Please ask for: Nicola Moore
Email: nicola.moore@arun.gov.uk
Telephone: Ext 37944
Our Ref: BE/134/21/PL
Your Ref:
Date: 12th August 2021

Application for Planning Permission

Development: Conversion of 1 No. dwelling into 2 No. dwellings. This application is in CIL Zone 4 and is CIL liable as new dwelling.
Location: 15 The Croft Bersted PO21 5TH

DRAWING
PROPOSED GROUND & FIRST FLOOR PLANS

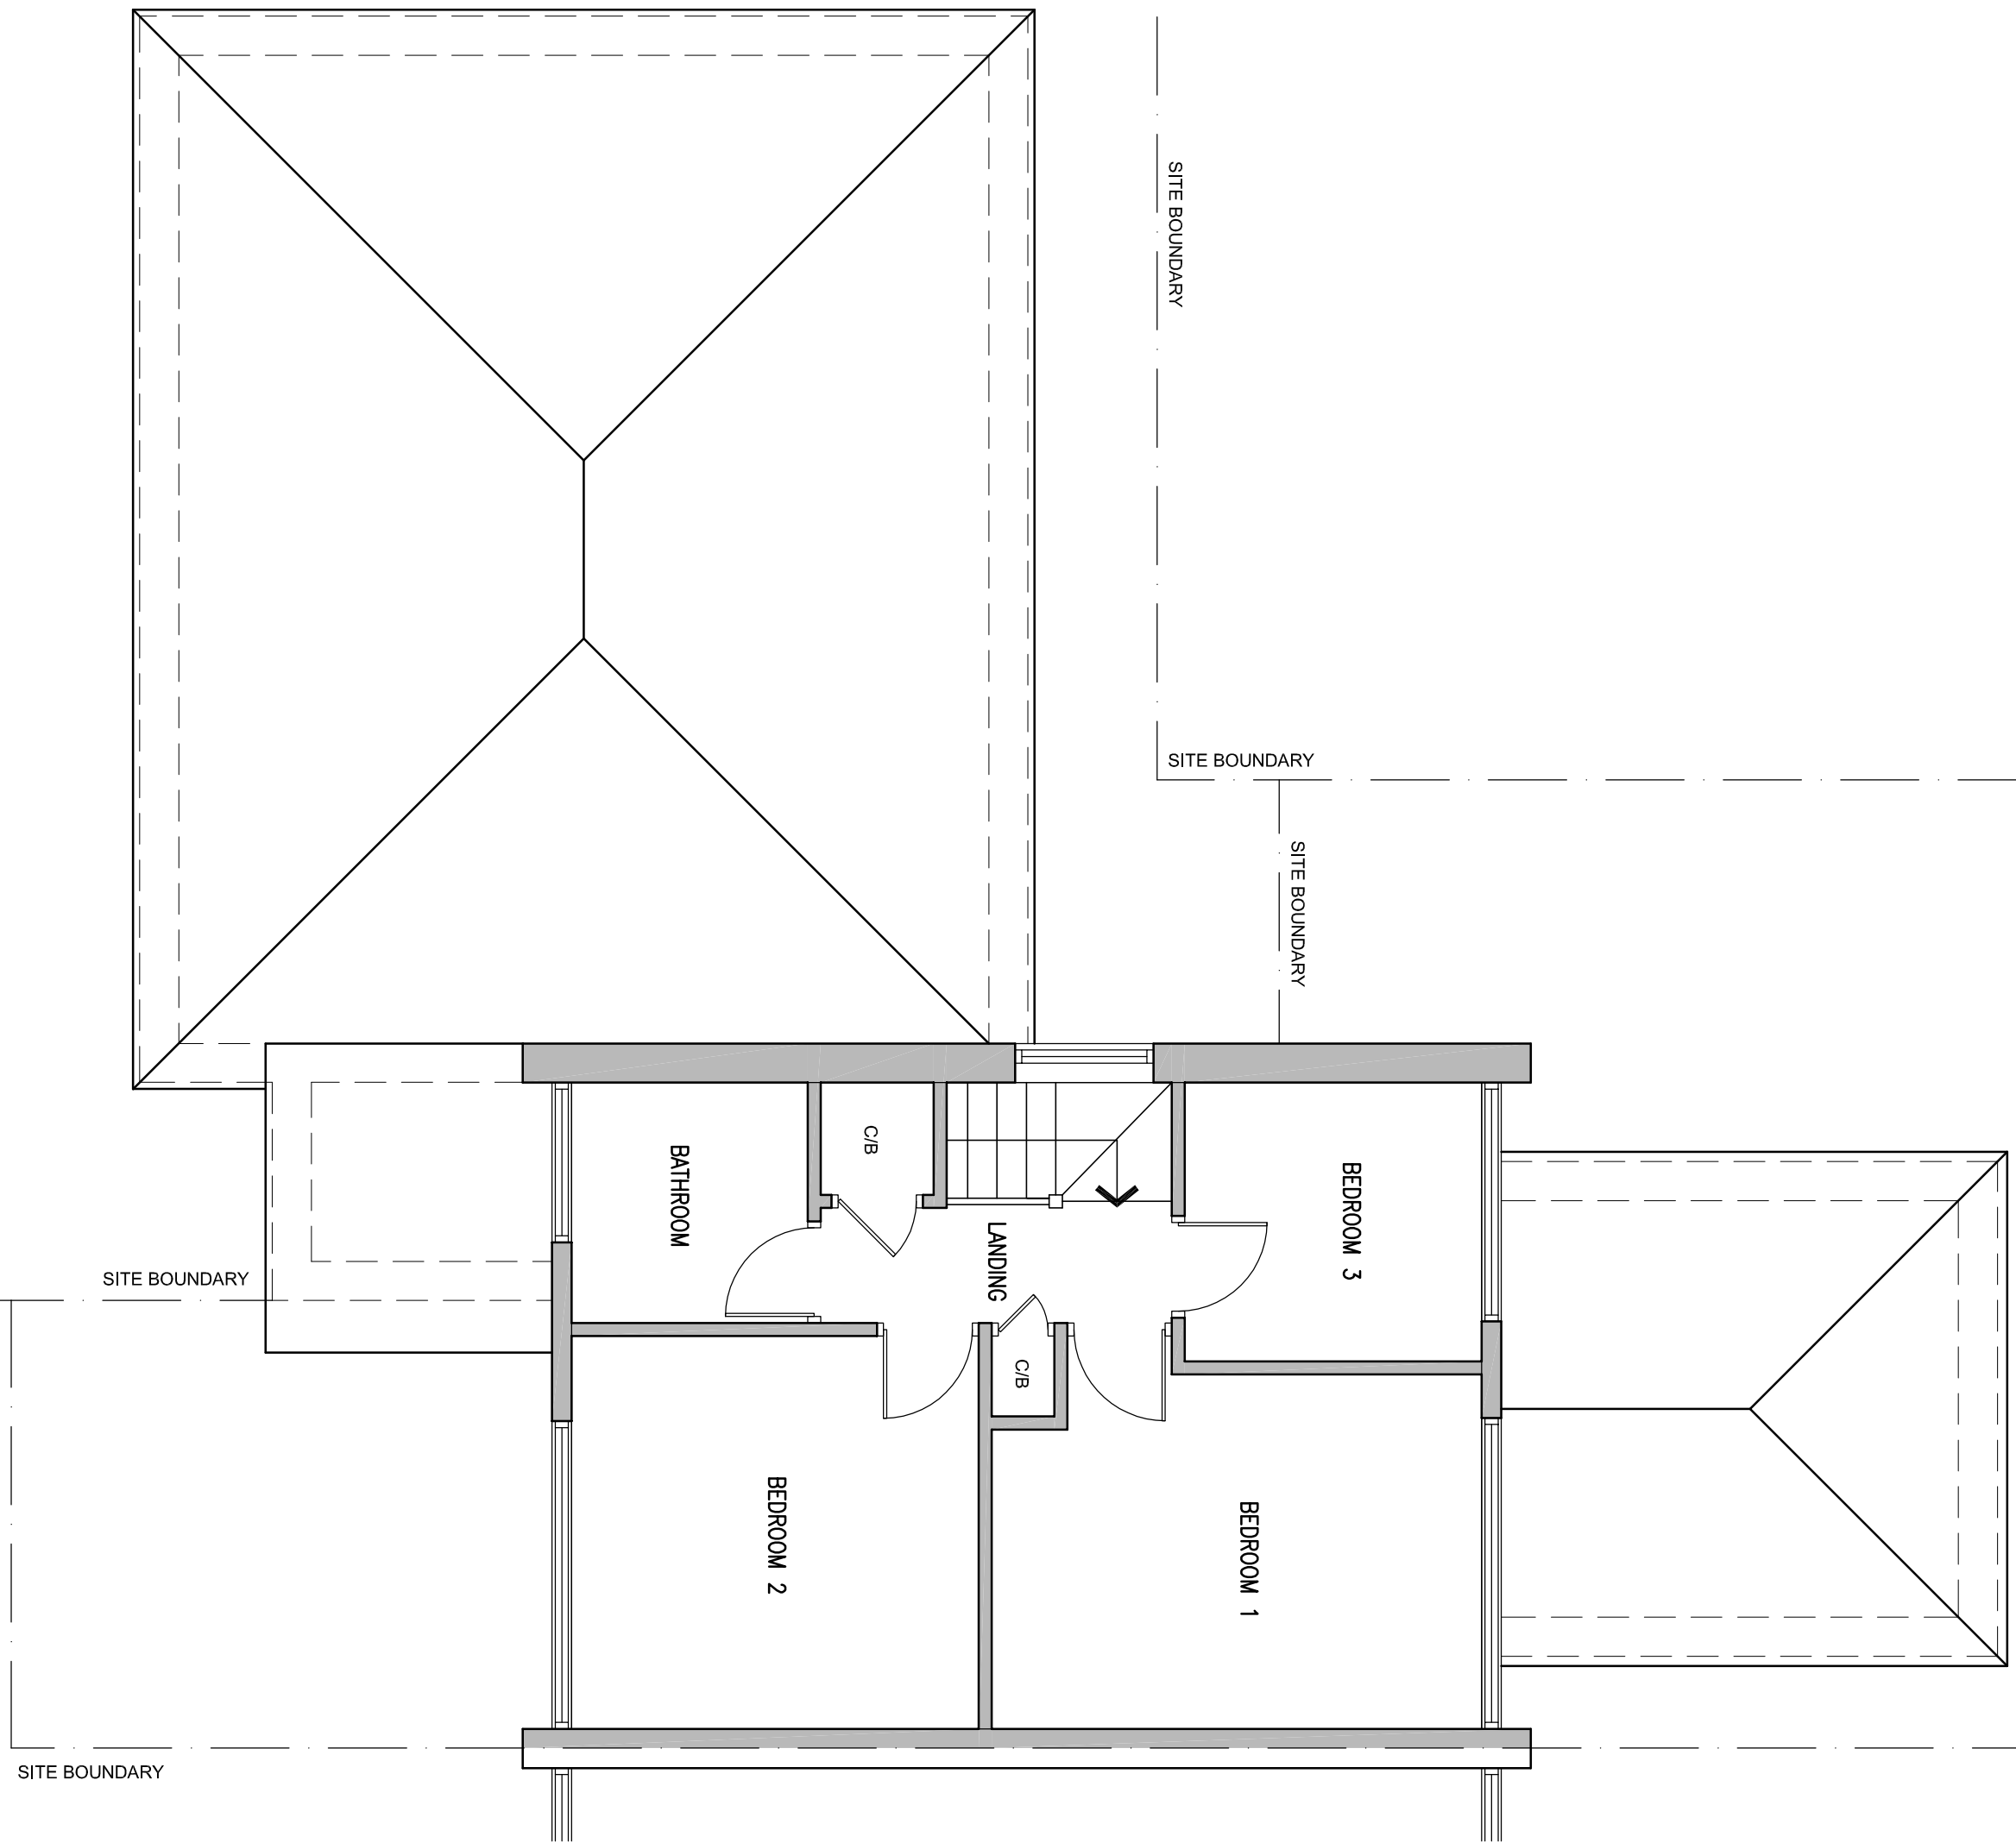
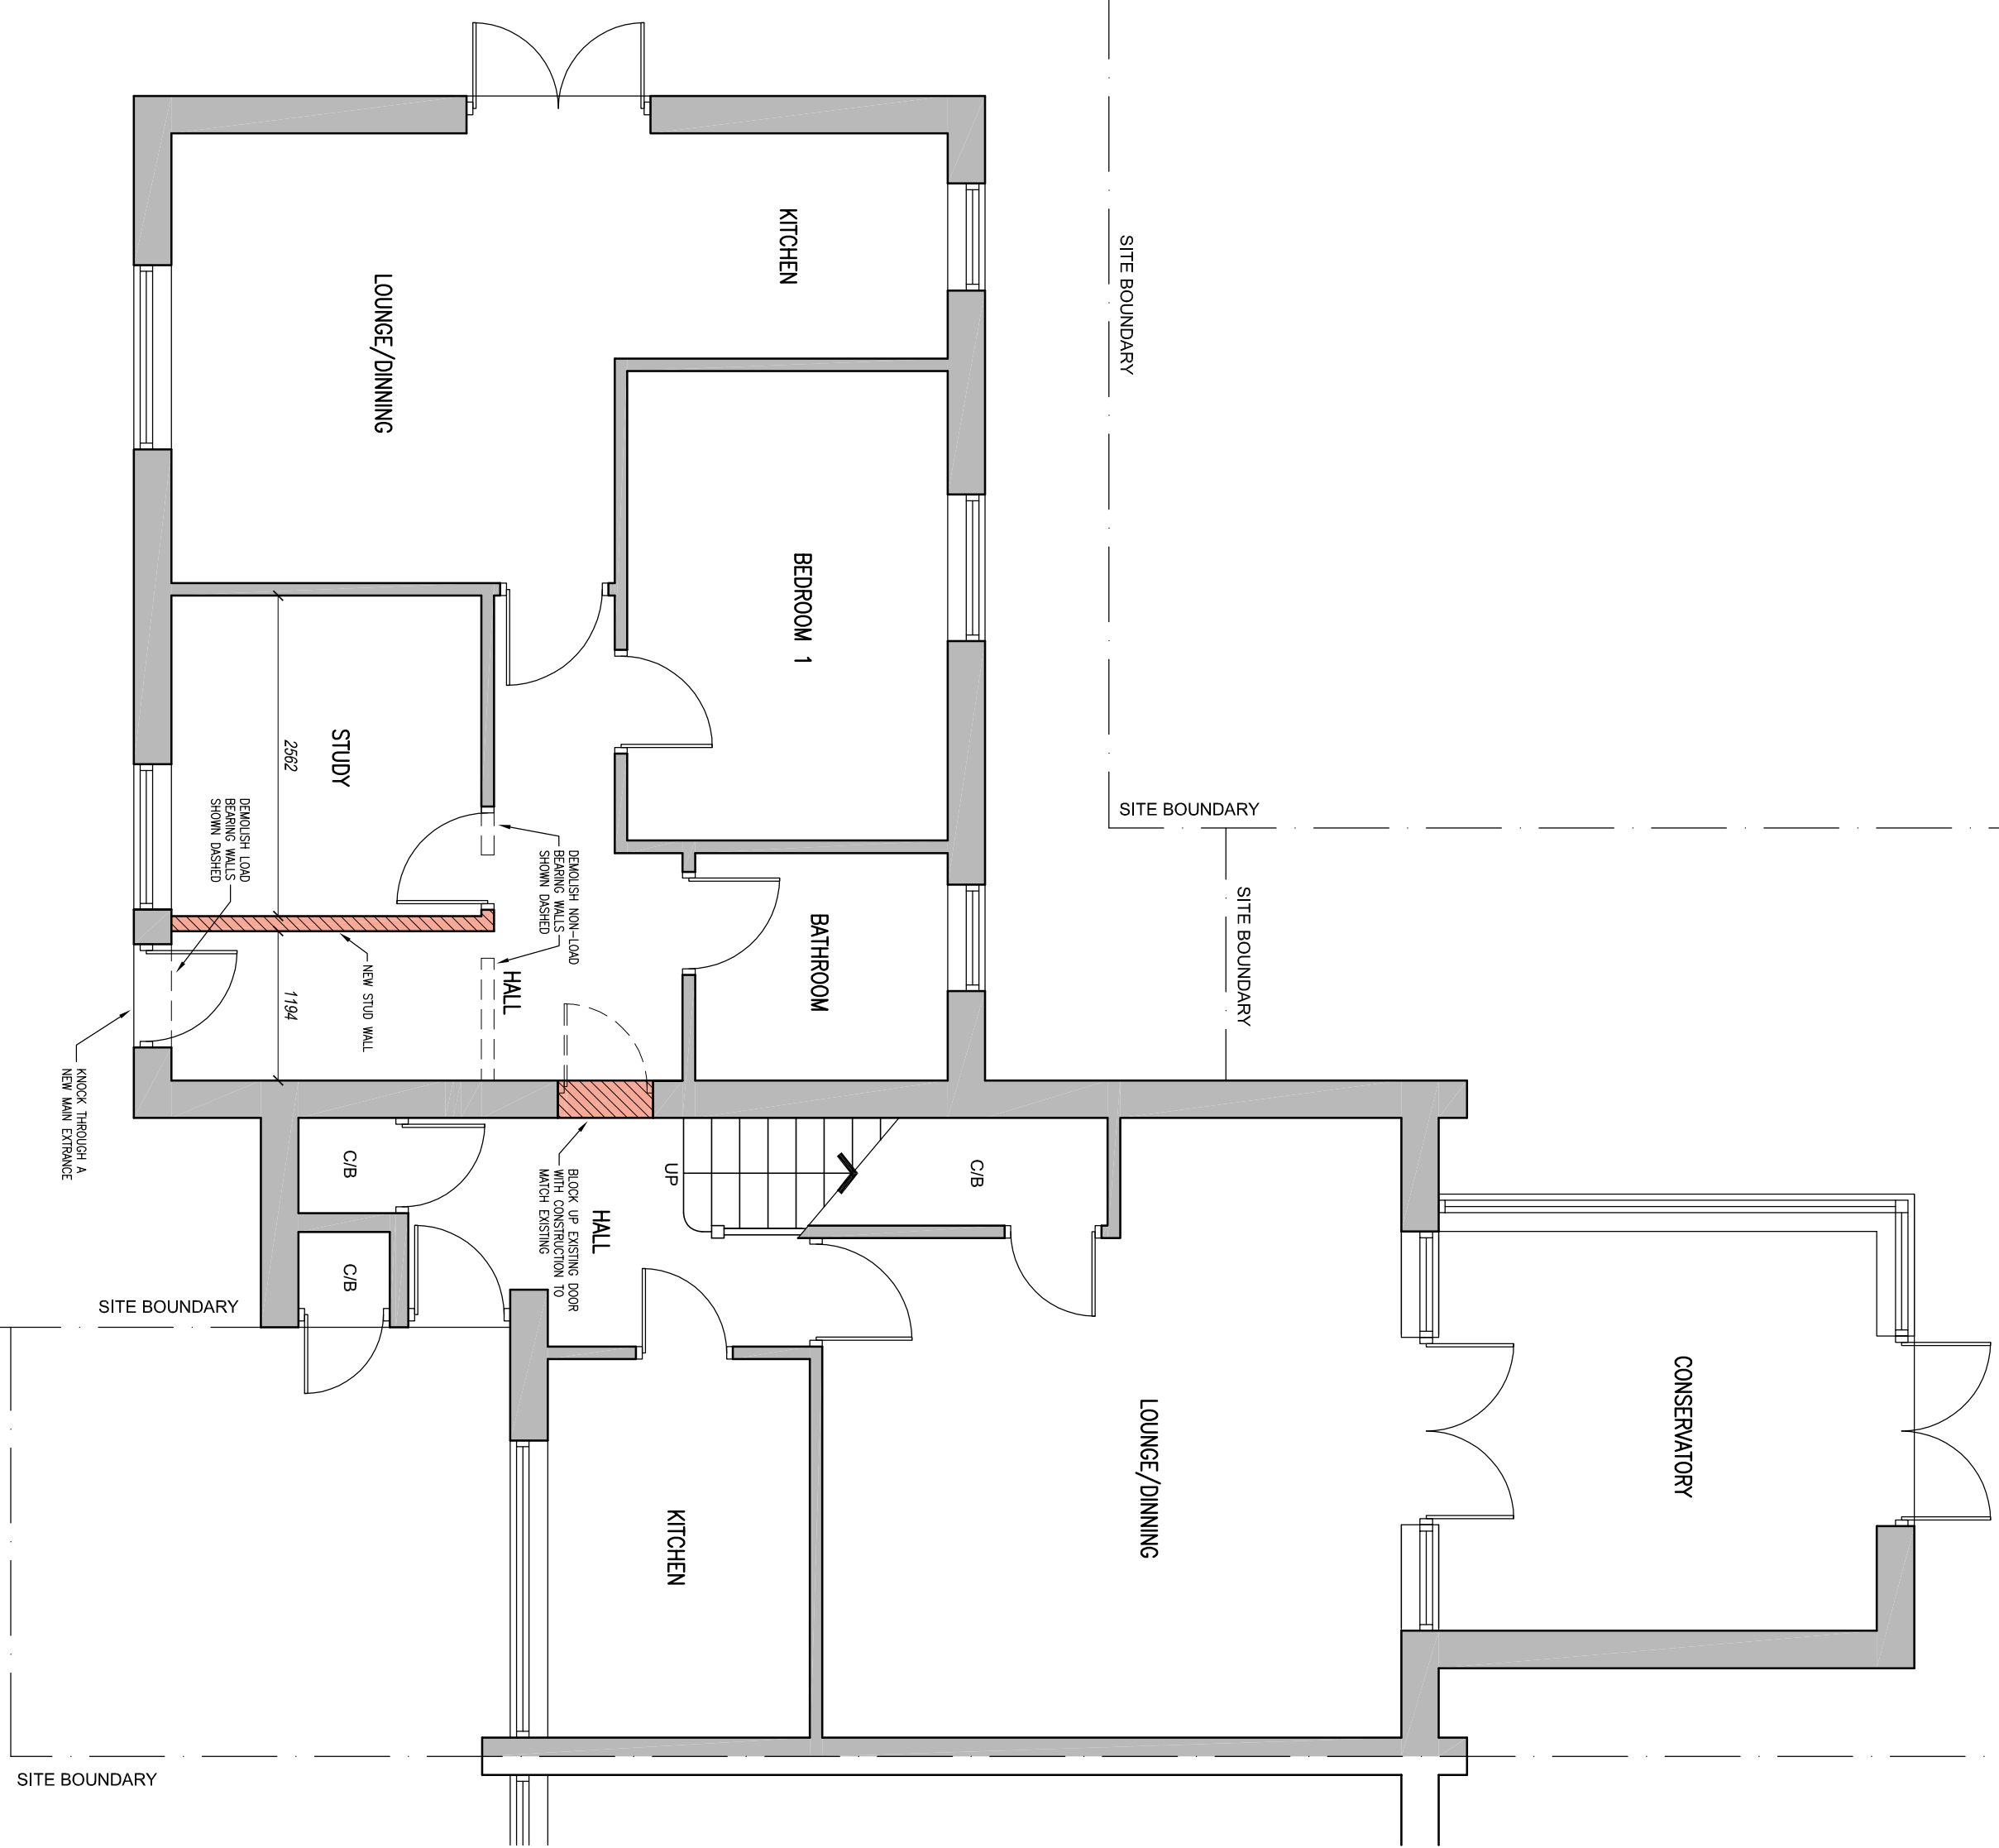
The proposed dwellings in Section 16 of the application form have been completed as 1 No. 2 bed and 1 No. 3 bed. However, the proposed floor plans and planning statement have 1 No. 1 bed and 1 No. 3 bed. Please amend accordingly and re submit.

LOCATION PLAN 1:1250

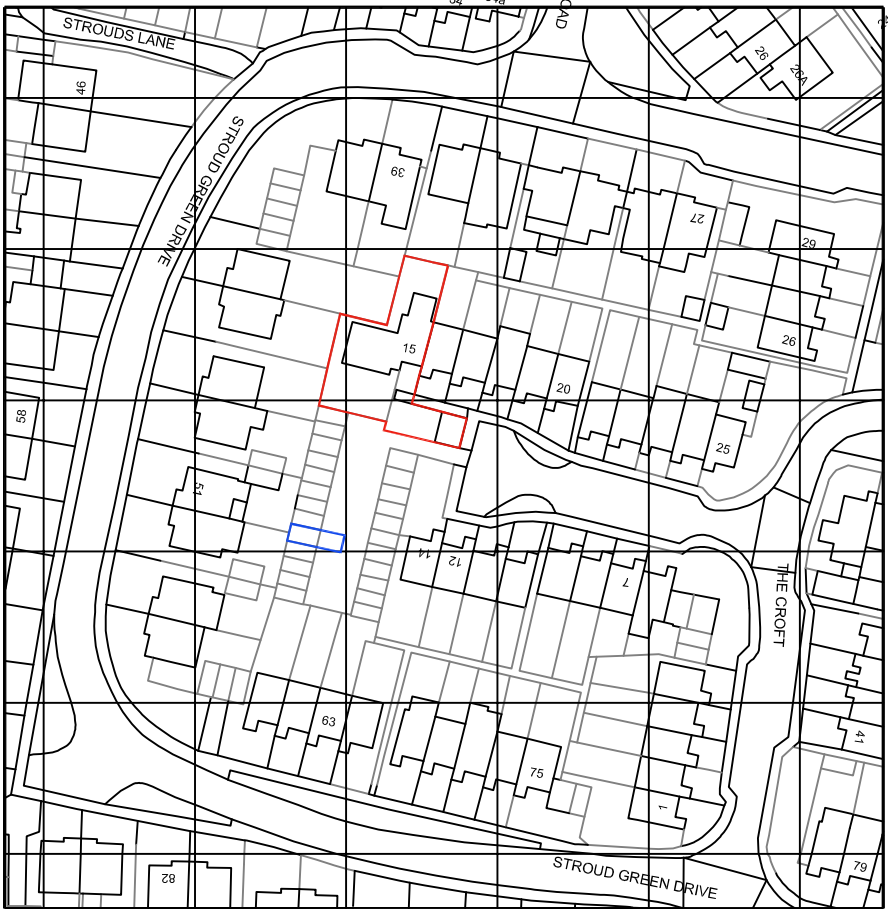
The Location Plan should include a North Point. Please amend accordingly and re submit. Further details of what must be included on the plan can be found in the Validation Requirements List.

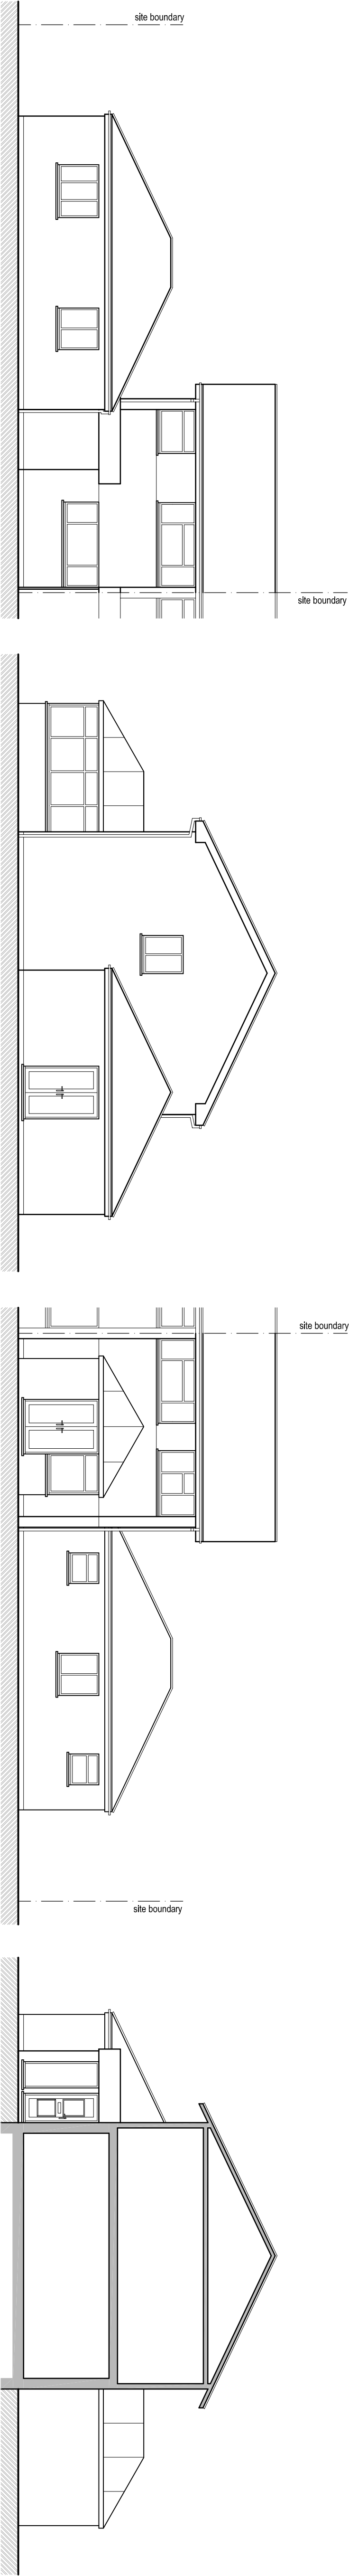
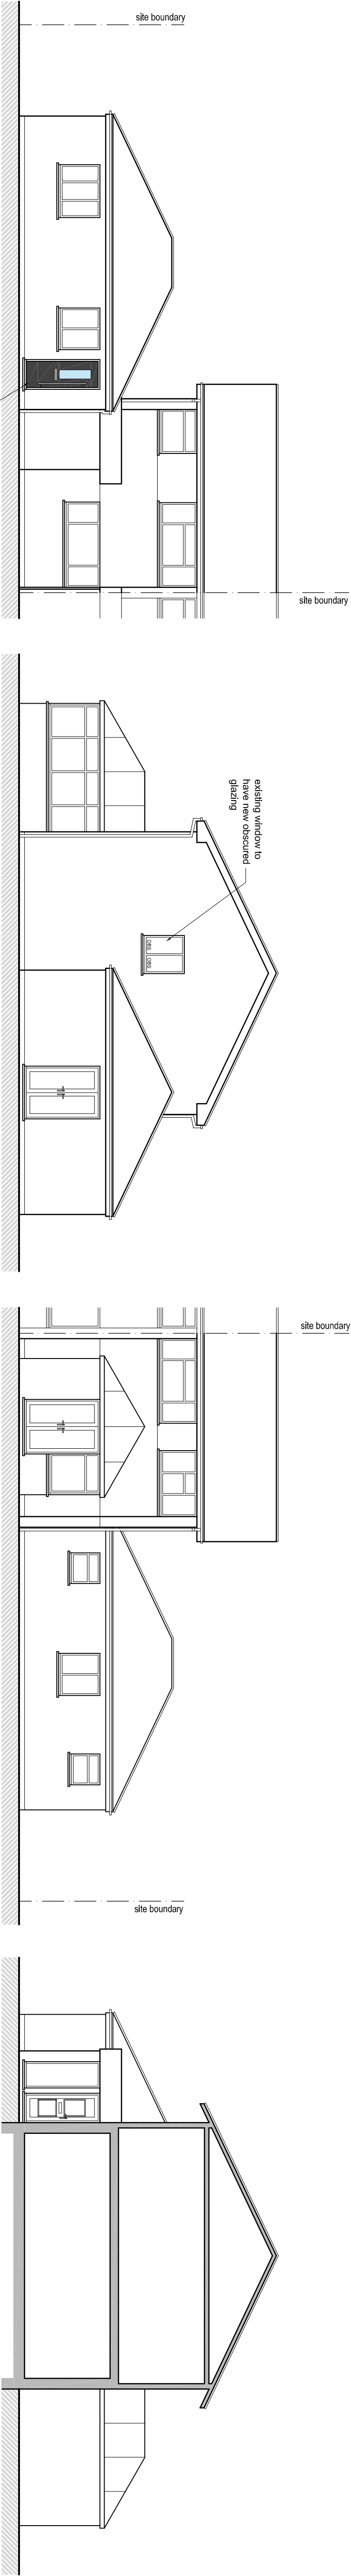
The scale bar on the Existing & Proposed Elevations is 1:100, but in the title is 1:50. Please amend accordingly and re submit. Further details can be found in the Validation Requirements List.
